Application No: FG/184/21/PL
Site Address: 1 Greenways Crescent Ferring BN12 5EF
Description of works: Erection of replacement dwelling and garage

OWPC41971

South Elevation

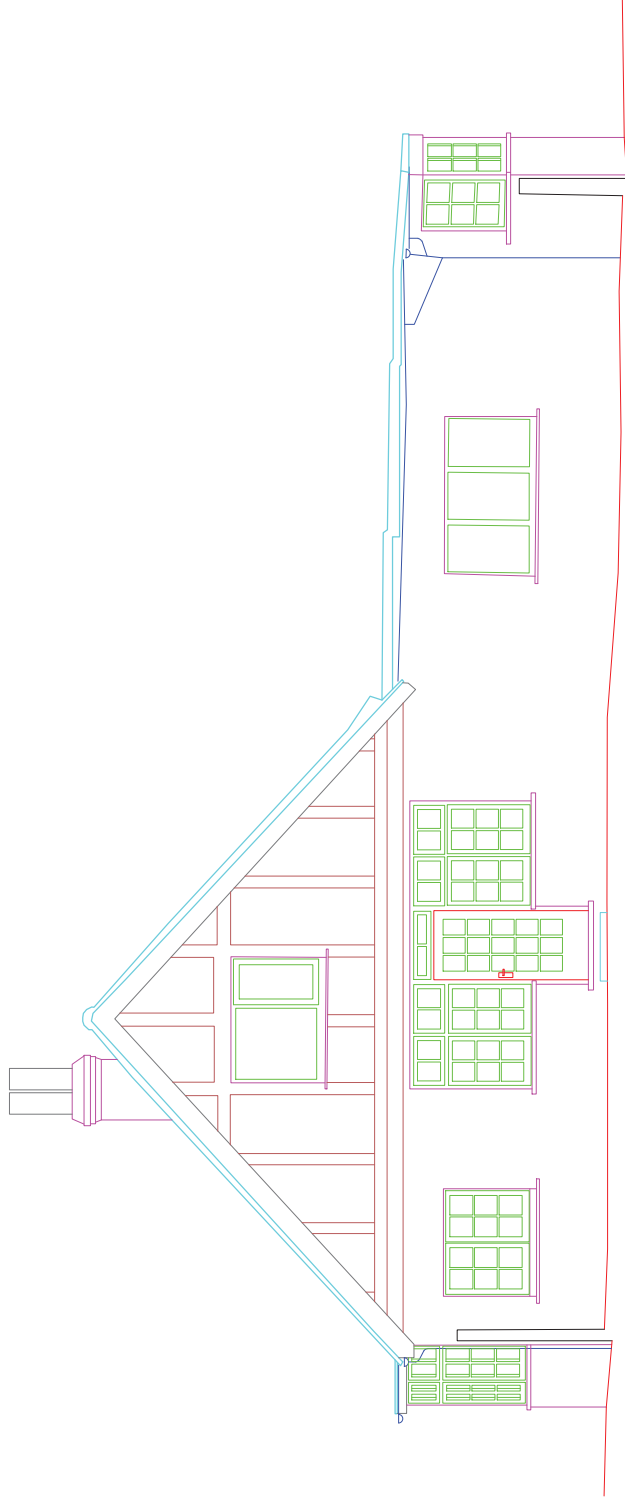
Ferring Parish Council have concerns that the windows on the first floor south elevation will give rise to overlooking of neighbouring gardens. As these appear to be non habitable rooms, we therefore request that officers give every consideration to making any consent conditional on these windows being obscure glazed and fixed below a minimum height of 1.7 m.
